18th September 2015

Attention: Fiona Gibson
Department of Planning and Infrastructure
GPO Box 39
SYDNEY, NSW 2001

SITE 8C, SYDNEY OLYMPIC PARK - PROPOSED MODIFICATIONS TO APPROVED DEVELOPMENT RESPONSE TO SUBMISSIONS

Site 8C Commercial Building  
Sydney Olympic Park  
Section BB

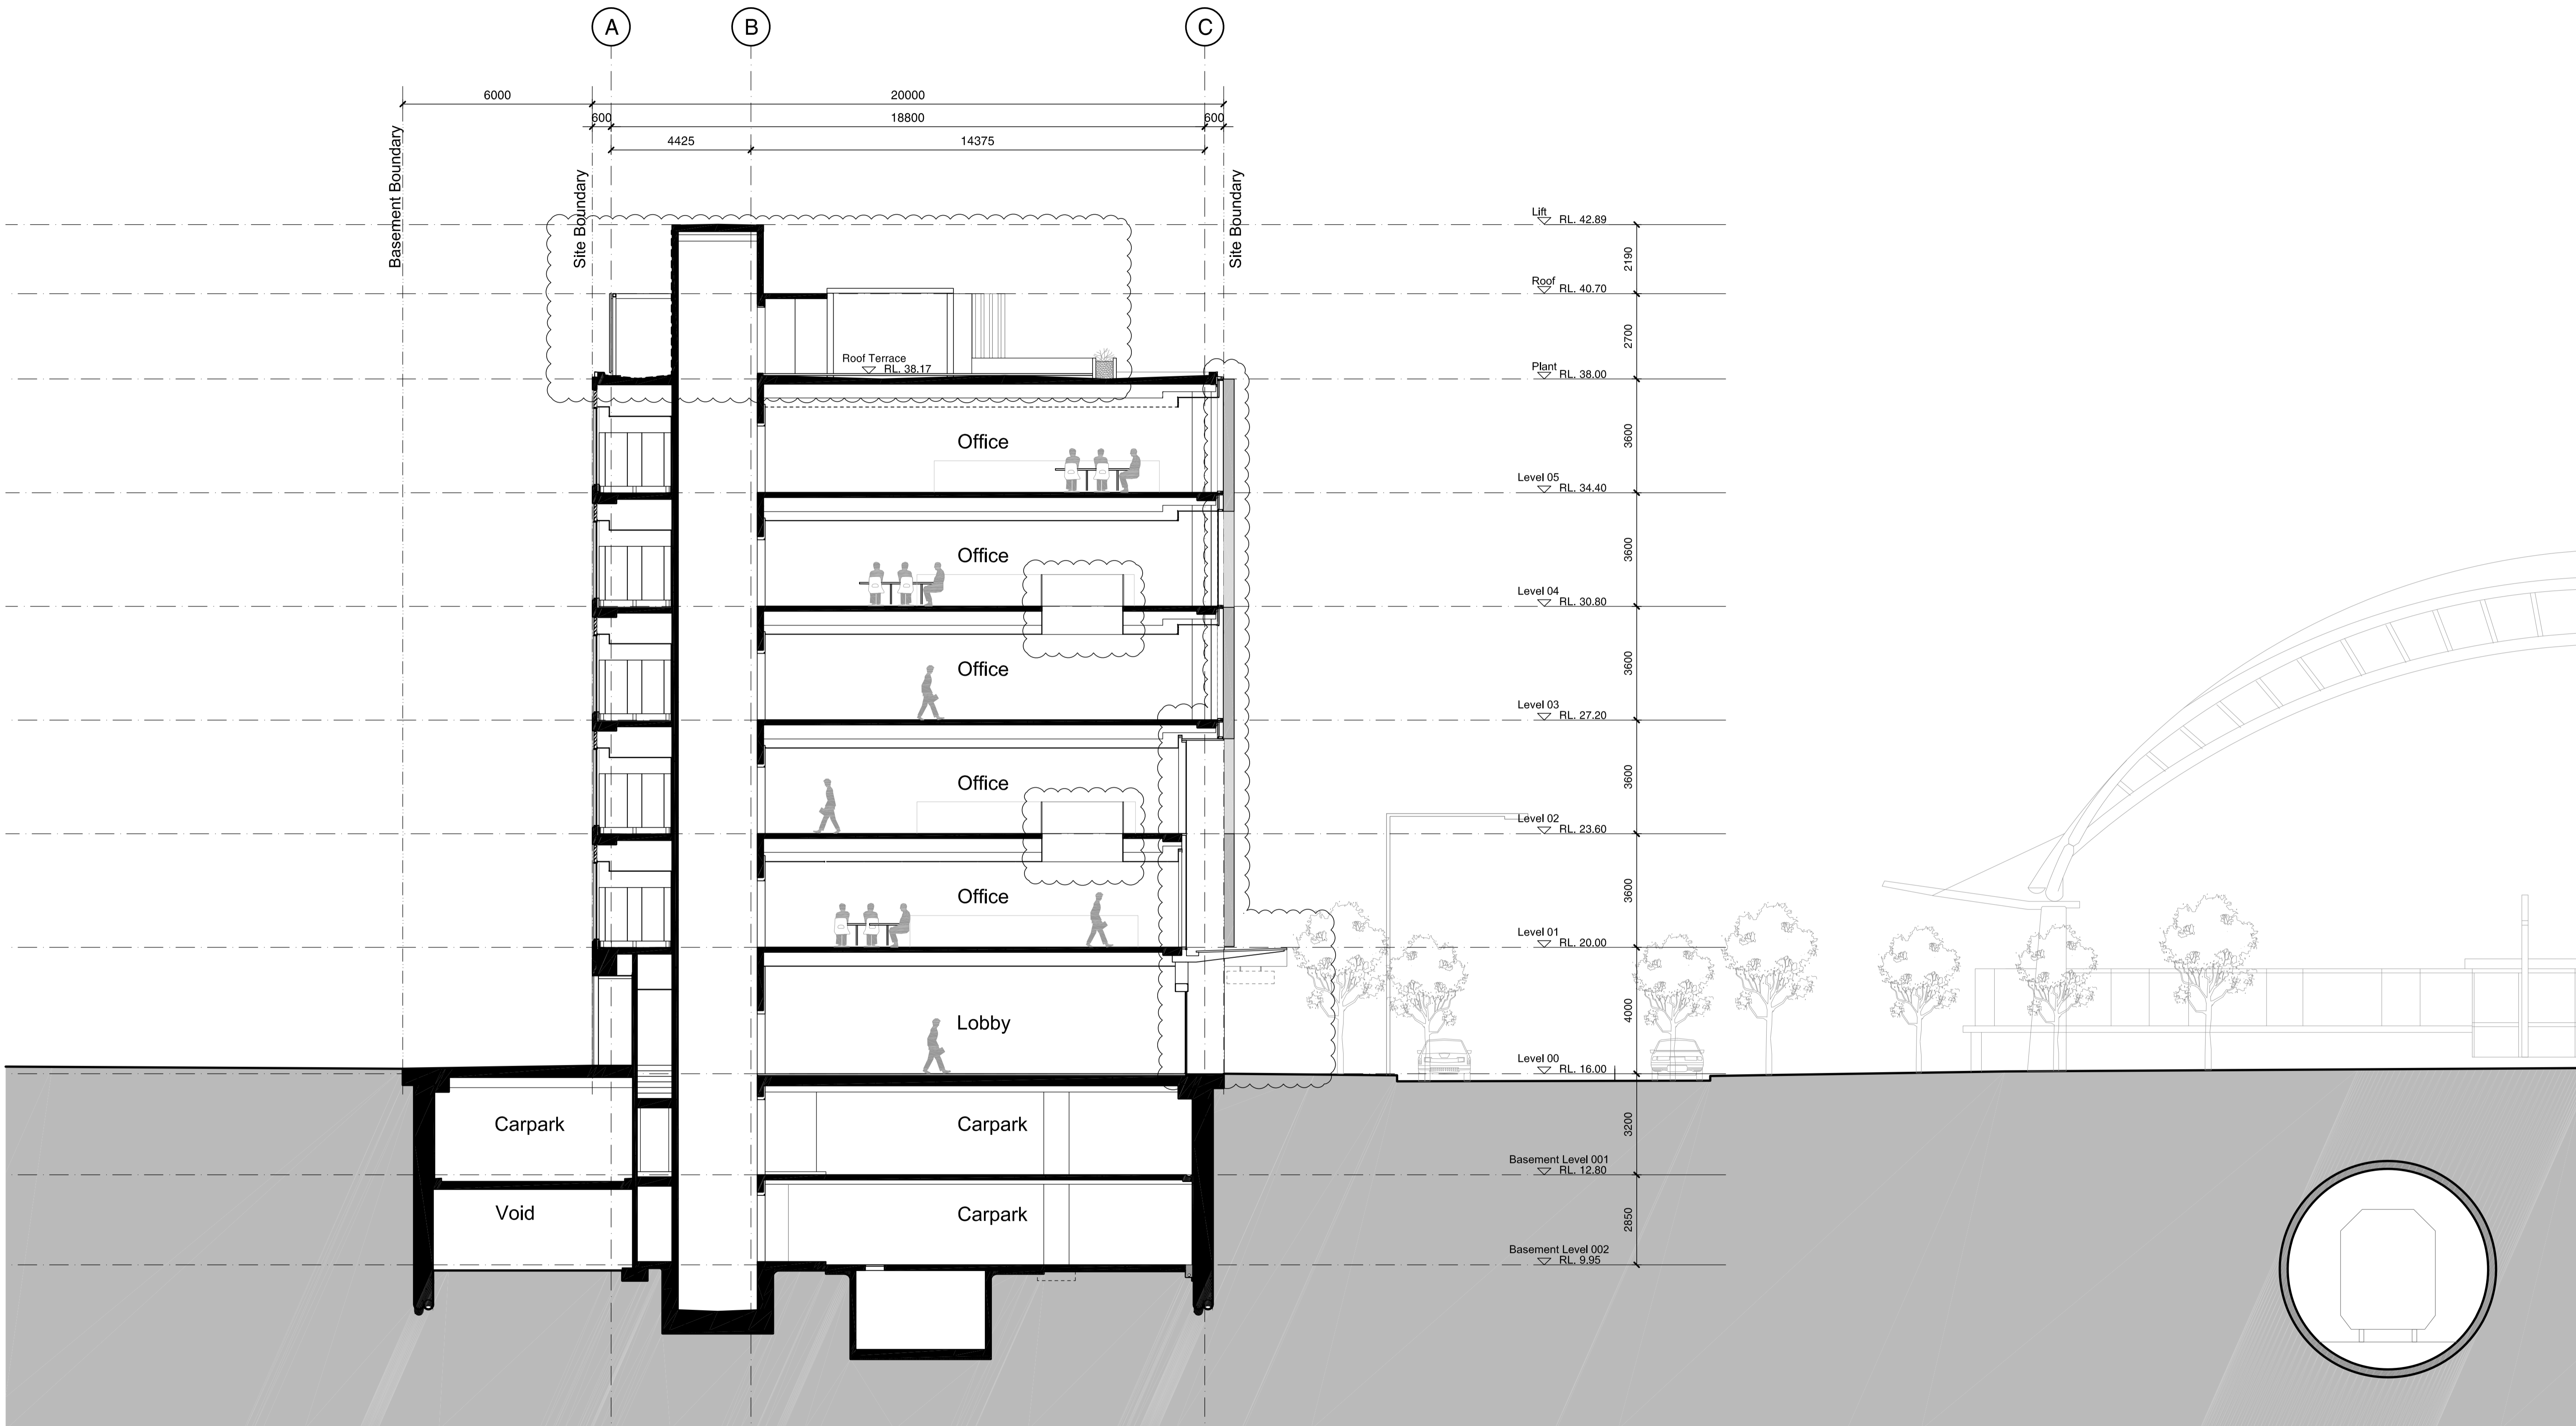
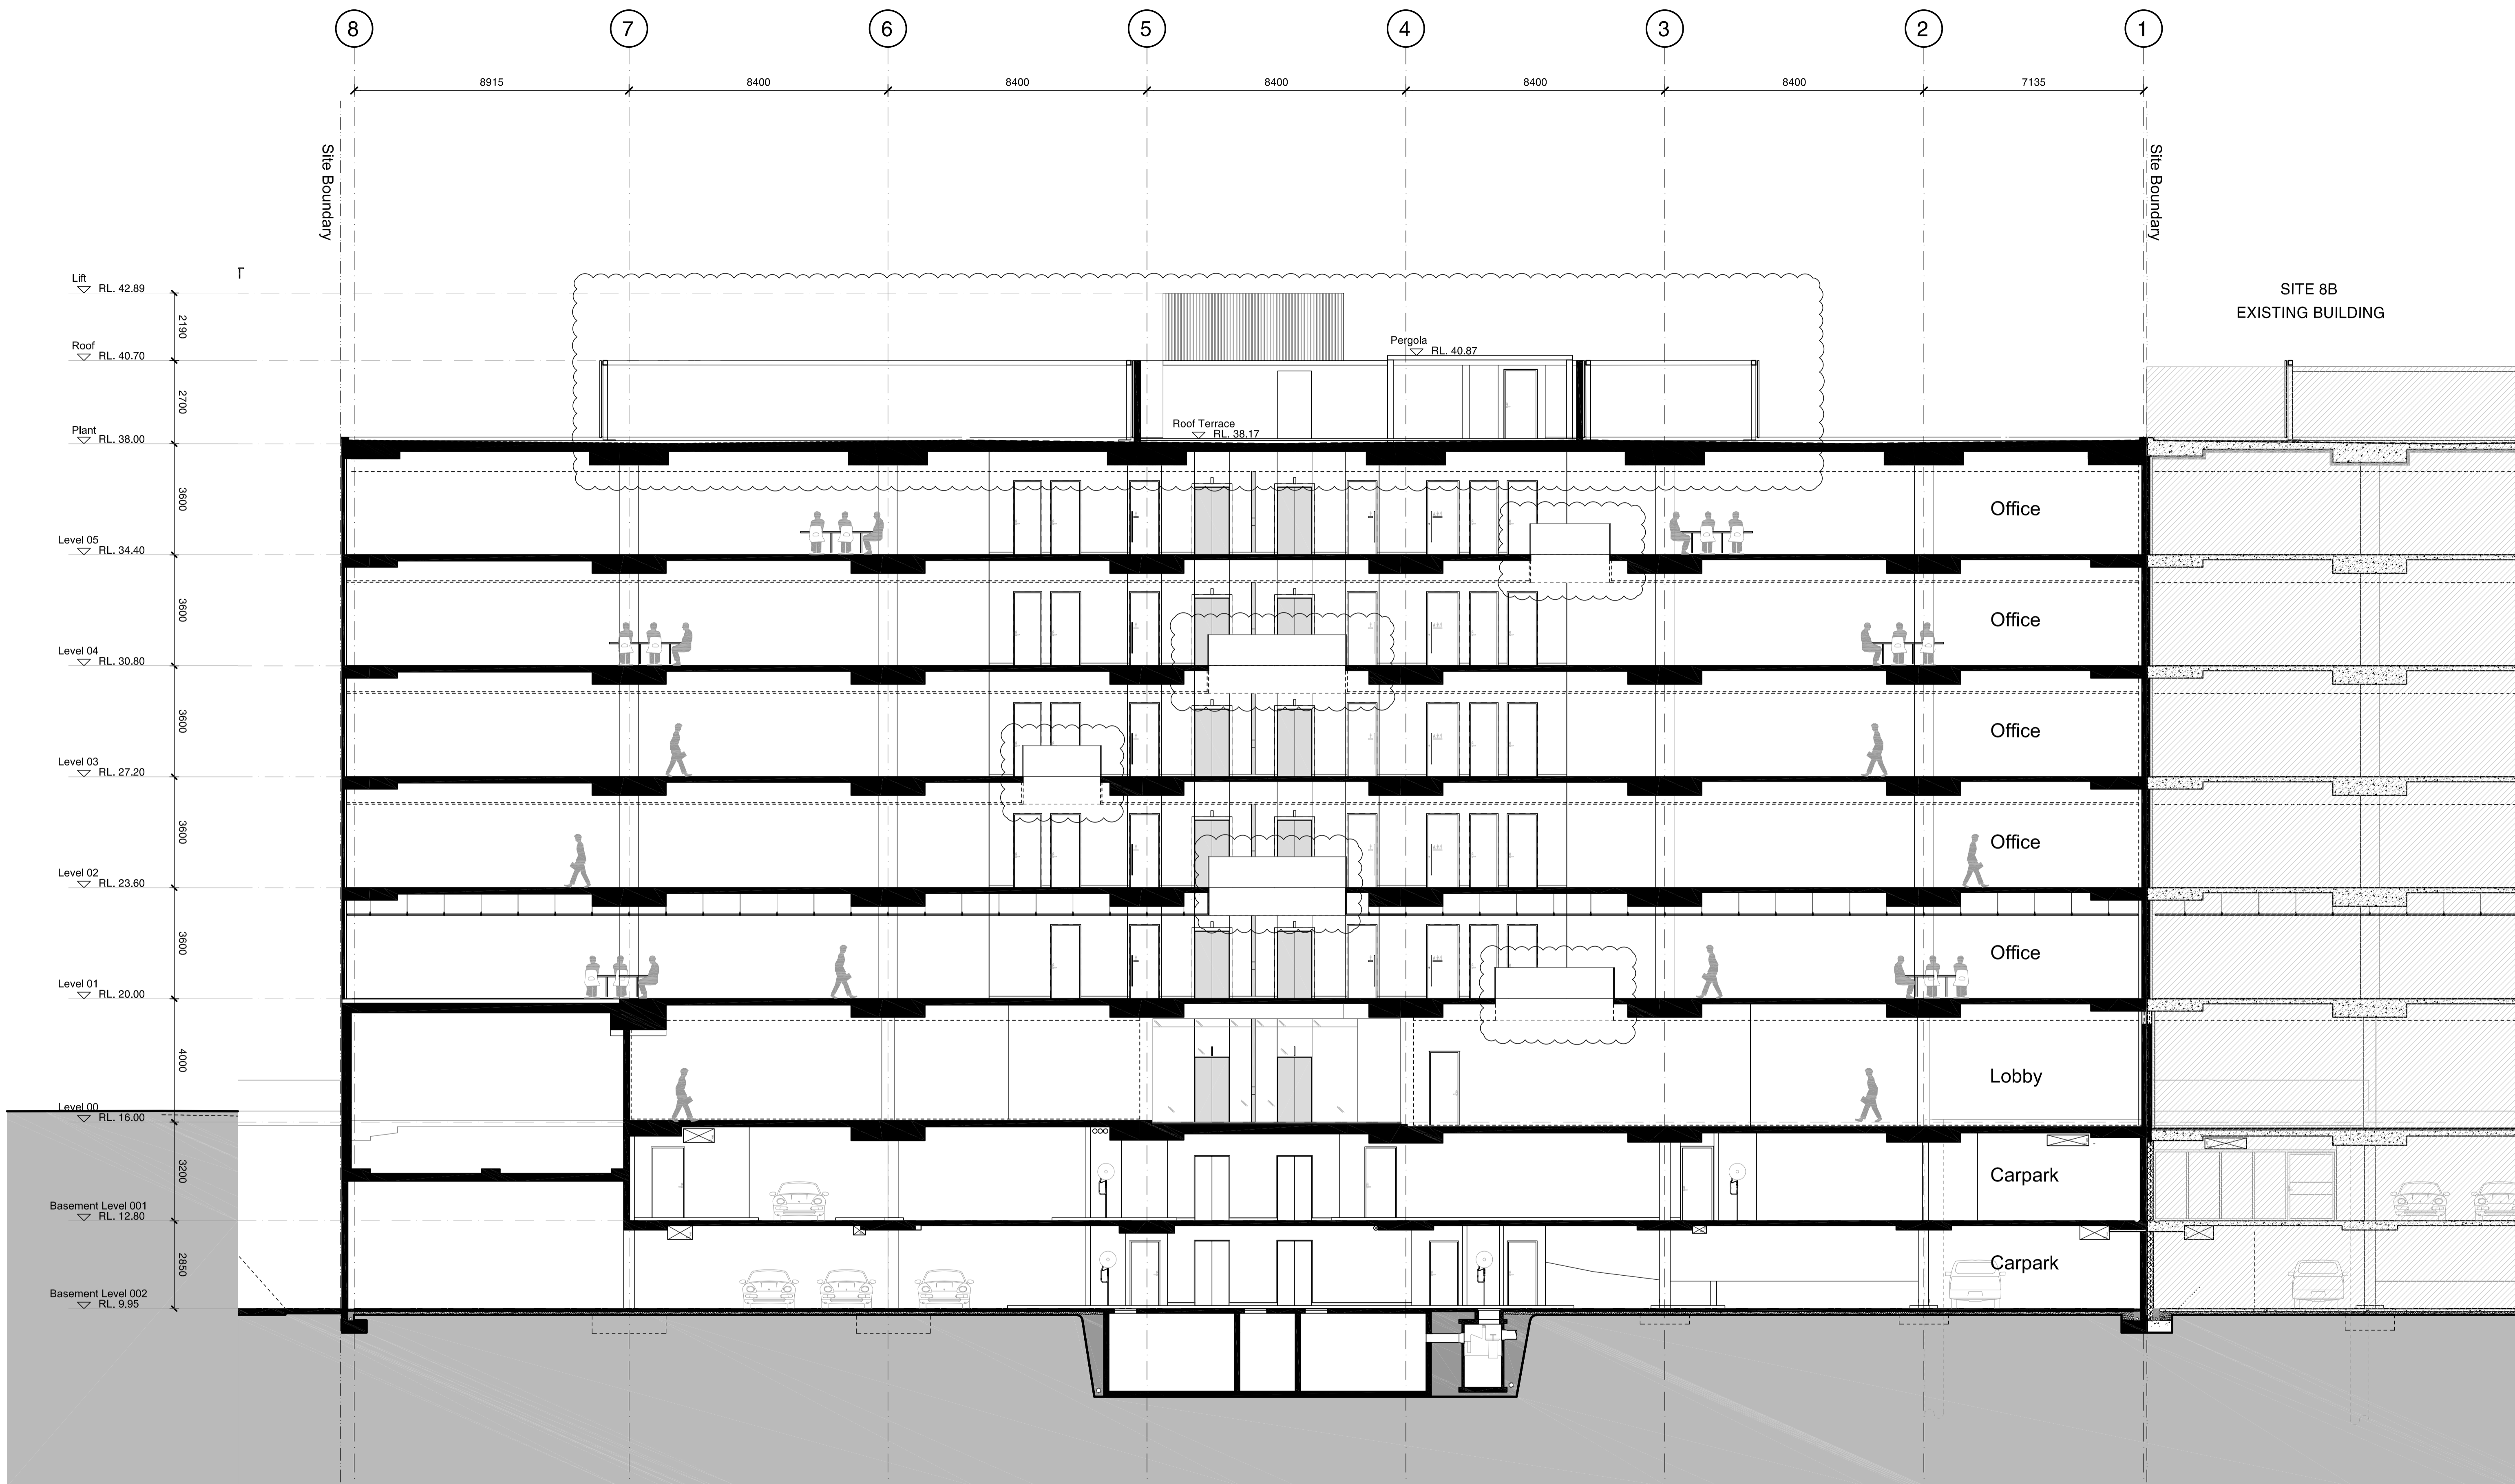
- *That the first and second floor slabs extended directly to the back of the portico. Ideally there should be a 3 storey high void to reinforce the scale impact of the portico.*
- *That new voids separating internal floors had not been coordinated with the facade design changes.*
- *That replacing half of the ground level tenancies with NRMA retail may deactivate the frontages if not properly fitted out.*
- *No further consideration of the 'green roof' recommended at the last DRP, however it was noted that one of the modifications is a roof deck proposed for staff.*
- *The finish to the top of the glazing*
- *Continuity of the character of the street awnings with adjacent development*

- *The first and second floor slabs (and edge beams) be set back from the portico. Ideally the new voids should be aligned to create a 3 storey atrium behind the portico, but at the very least a metre set back from the glass is recommended.*
- *The ground level NRMA fitout should present an active and vibrant frontage to the street – i.e. no blinds, joinery fixtures or furniture against the glass.*
- *Glazing at ground level should be frameless if possible, or with mullions at maximum spacing.*
- *A green roof be considered in conjunction with the new roof terrace.*

The DRP's recommendation for a three storey atrium behind the portico is inconsistent with NRMA's required operational layout and will significantly affect their proposed internal fitout. Despite the DRP's concerns, FDC believe that the slab edge will not result in an unreasonable architectural outcome on the basis of the following points:

- All slab edges for the entire façade will be immediately behind the glazing and are screened from view by colour backed glazing. This coloured band matches the tint of glazing and is therefore only visible at night when internal lights are on, showing the slab edge to every floor along the southern elevation. This is the same for the adjoining development on Site 8B where slab edges are positioned directly behind the façade and are thus subtly screened from view. This will be exactly the same for the portico section of facade;

- The first floor slab edge sits immediately behind the proposed awning. The slab edge, although hidden behind colour backed glazing, will also be hidden by the lineal element of the awning for the entire length of the façade and within the portico. Furthermore, the slab will provide structural support to the awning, suggesting that its position immediately behind the glazing is more appropriate than providing a one metre setback;

- The second floor slab band, again positioned behind colour backed glazing, is again subtly lost from view behind the proposed indicative NRMA signage which sits immediately in line with the slab edge (Please note, the NRMA logo may be subject to change – current logo provided only to illustrate proposed signage zone and intent of entry feature signage);

For these reasons, the proposed portico will remain as currently proposed. We do not agree that a three storey internal atrium is necessary to improve the external appearance of the proposed portico.
